23rd November 2016

**Regarding:**  
**Project #:1010550 Case #:16EPC-40040**  
**Official Notice of Decision dated November 14, 2016**  
**Conditions of Approval and Comments Response**

C-0041

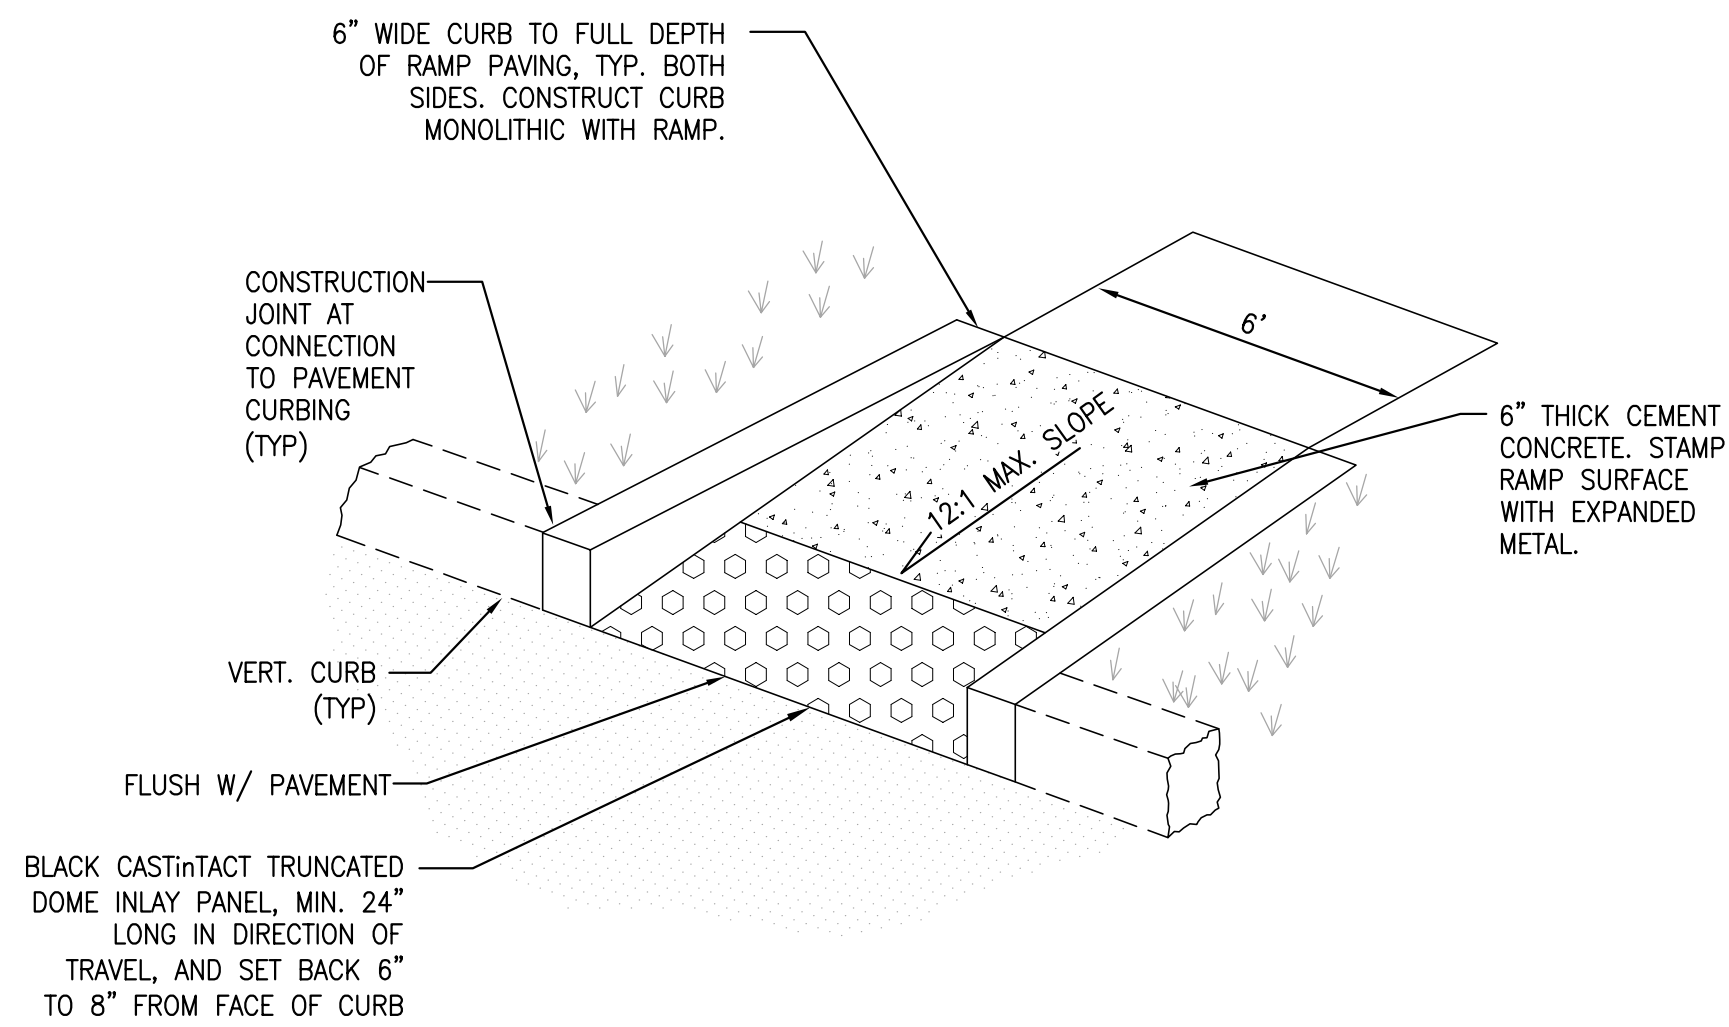
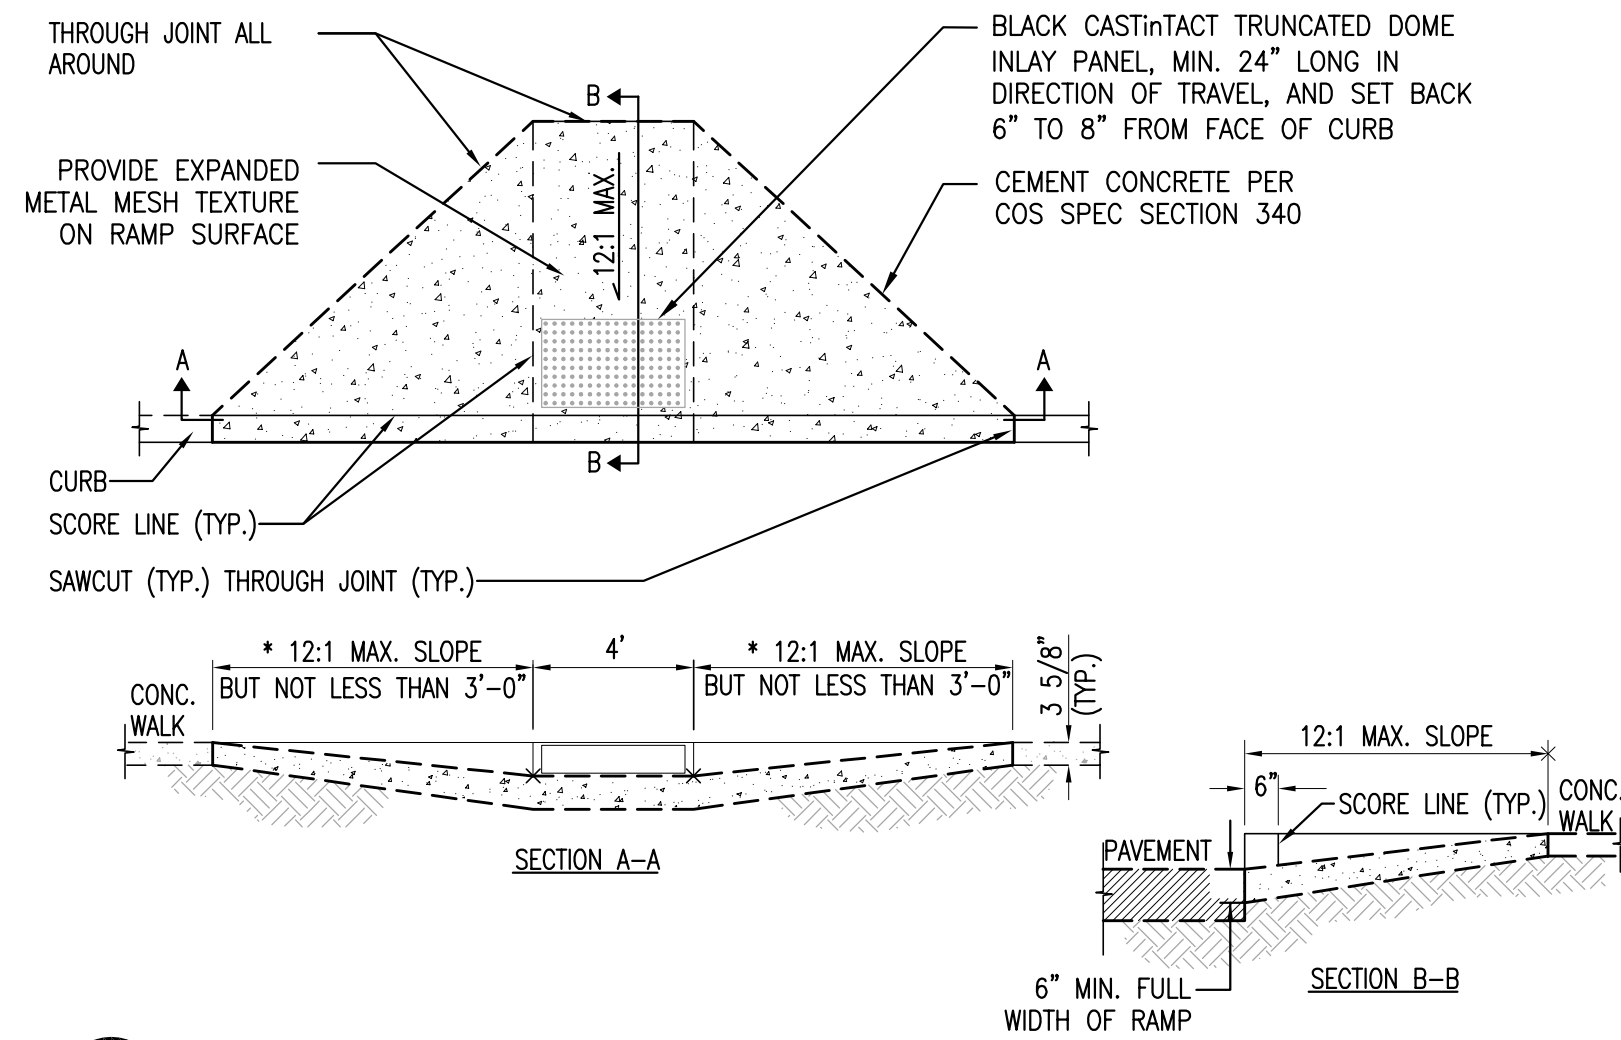
- a. Refer to note C. on sheet SP-1.
  - b. Refer to note D. on sheet SP-1.
  - c. Refer to Pedestrian Connection plan on sheet A-1002. Location of crosswalk and 6' accessible pathway is limited due to the grading from Wyoming Blvd NE onto the site. Location is also set based on the least congested vehicle traffic area. There are illuminated bollards and pavement markings to draw attention to pedestrian/vehicle traffic at crosswalk. Keynote 32 on A-1002 Site Plan added to clarify pathway crosswalk will be concrete.  
Also, refer to C-0041 for ADA ramp details.
